Date: 23 June 2026

STATUTORY PLANNING CONSULTATION RESPONSE

Application Number:	3/2026/0238
Proposal:	Approval of details reserved by conditions 3 (construction management plan/method statement) 4 (surface water) 5 (bat boxes) 7 (street maintenance) 8 (flood mitigation) 9 (flood management plan) 10 (surface water/foul drainage) 19 (cycle storage) 20 (travel plan) and 21 (operation/maintenance manual) on planning permission 3/2022/1158 granted on appeal APP/T2350/W/25/3368139.
Location:	Land South of Accrington Road Whalley

CONSTRUCTION SURFACE WATER
MANAGEMENT PLAN

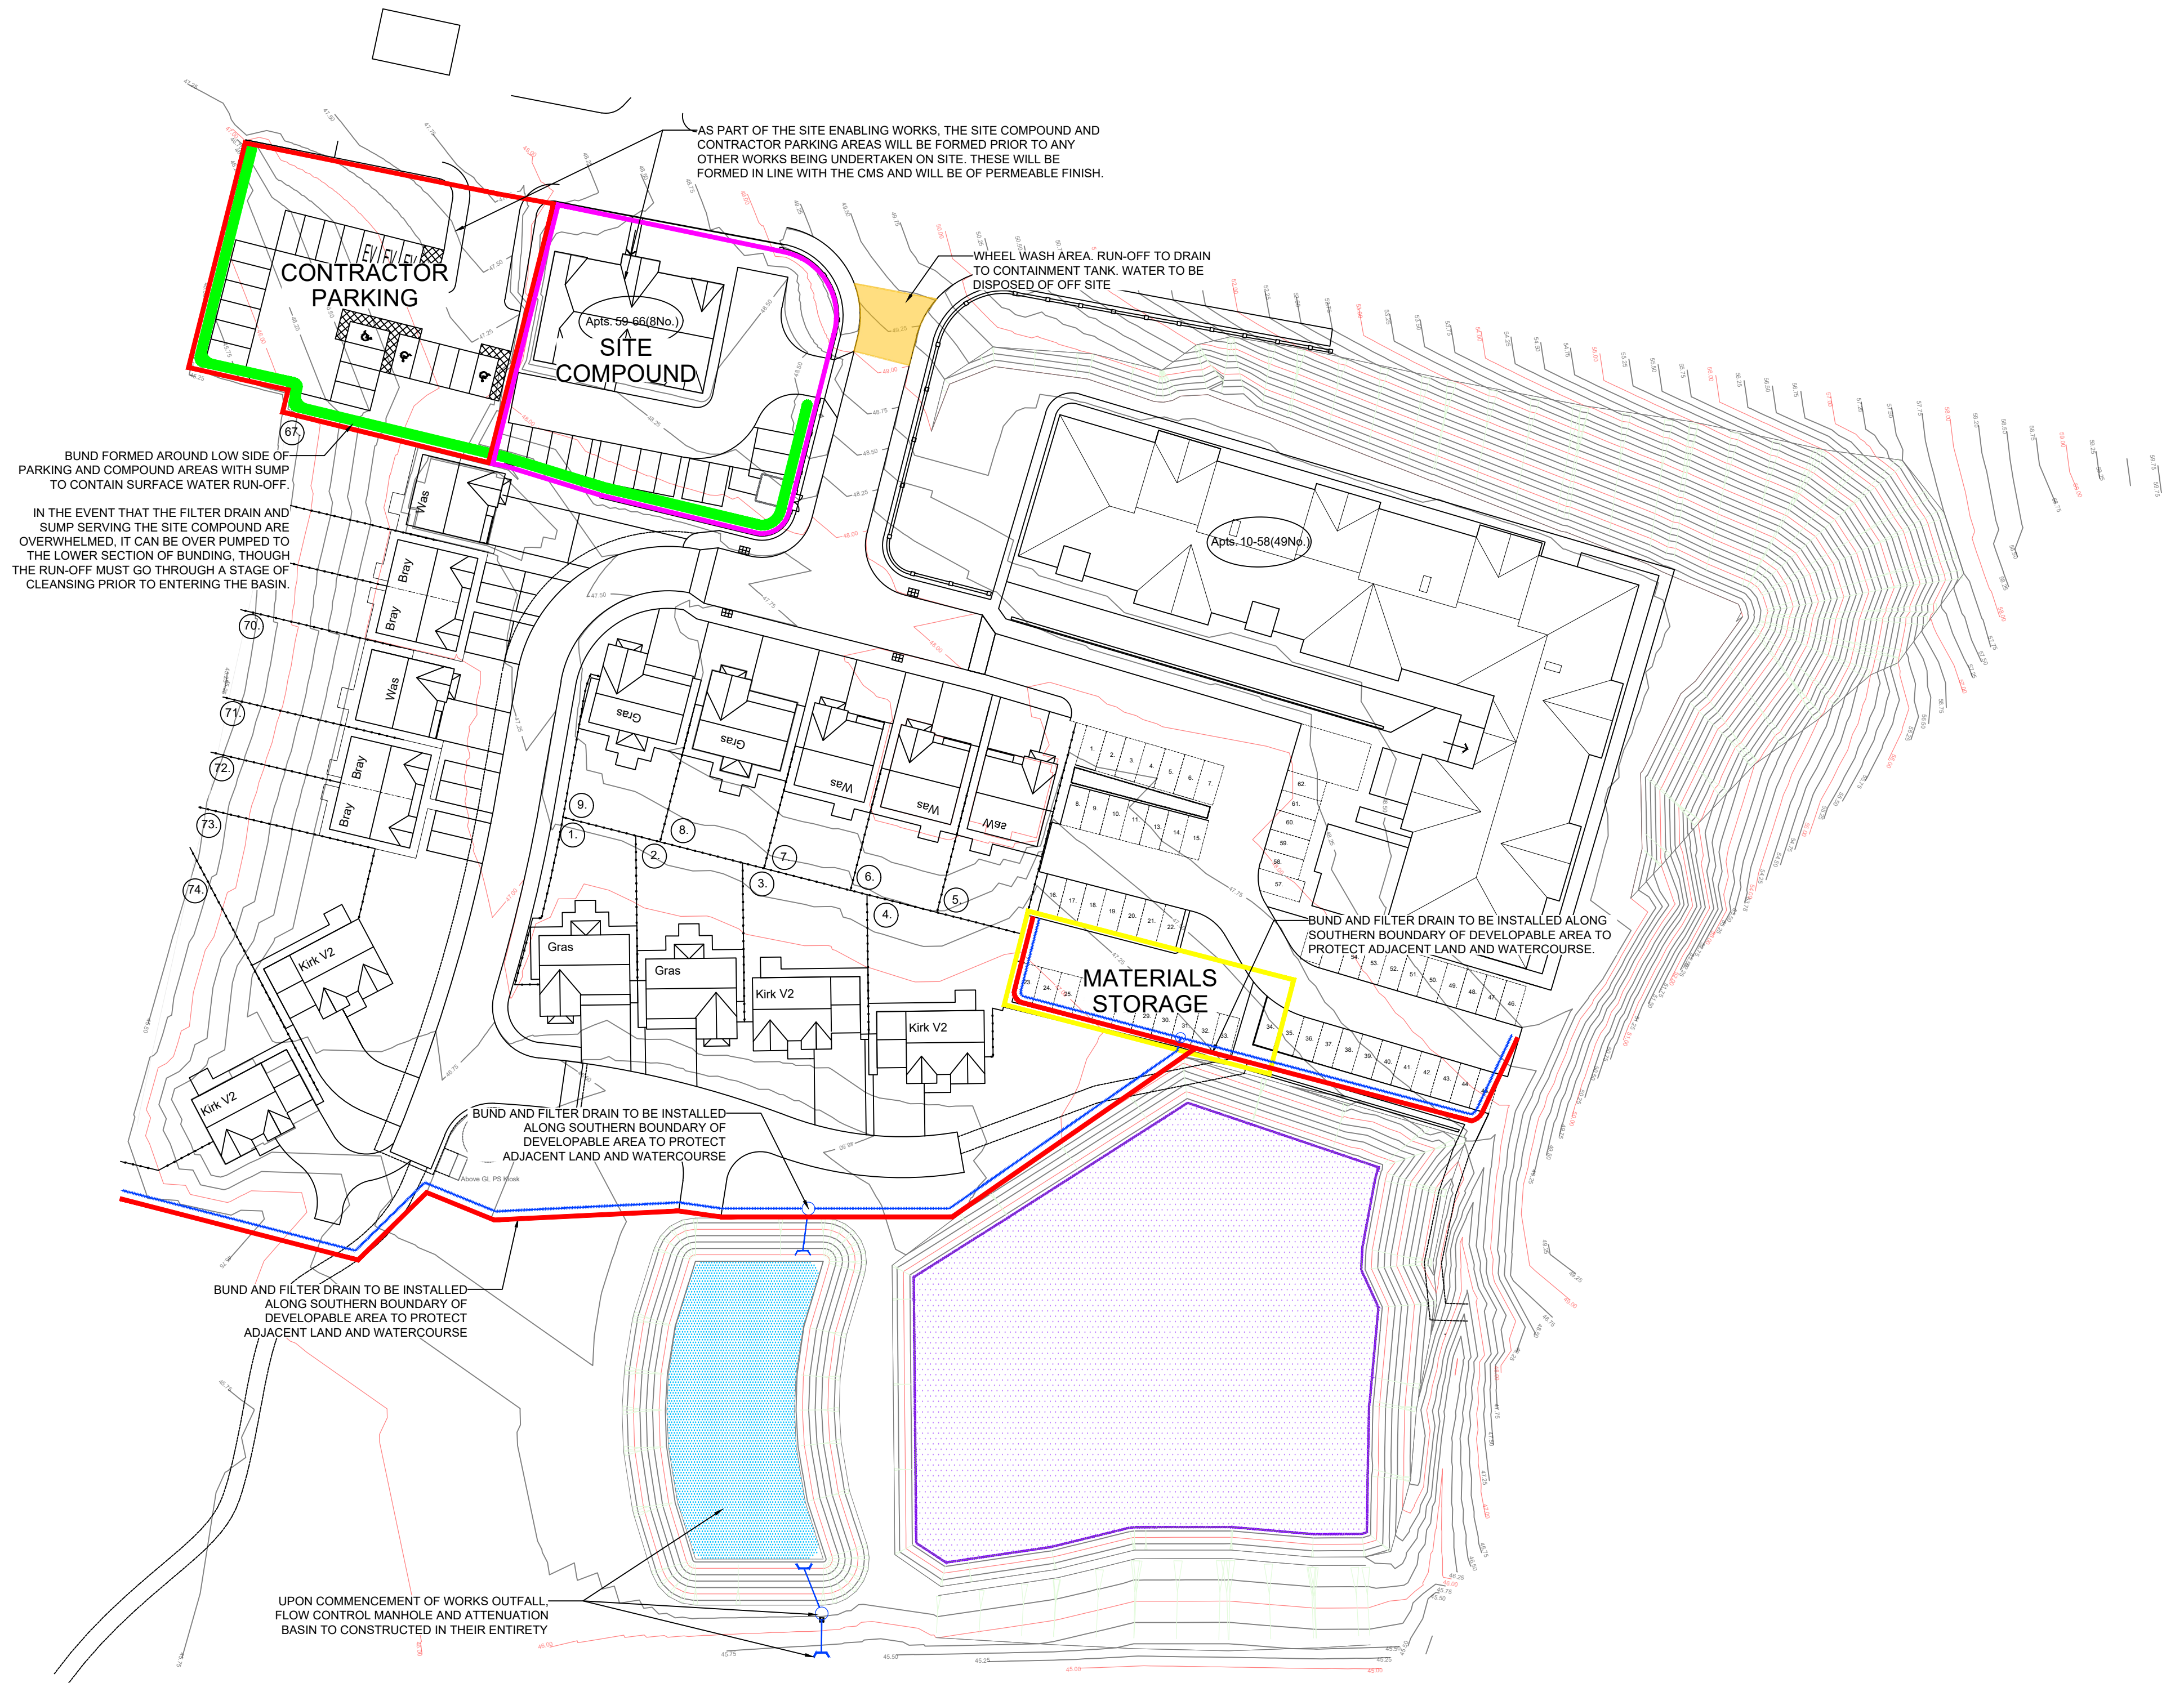
- The applicant has failed to provide evidence to demonstrate how surface water will be disposed of and at what rate from the areas it has indicated as being bunded

during the construction phase. Should the applicant intend to pump the surface water from these areas to the proposed attenuation pond, it will still be expected to be shown how these bunded areas are expected to be drained and at what rate prior to the construction of the attenuation pond and the proposed hydrobrake.
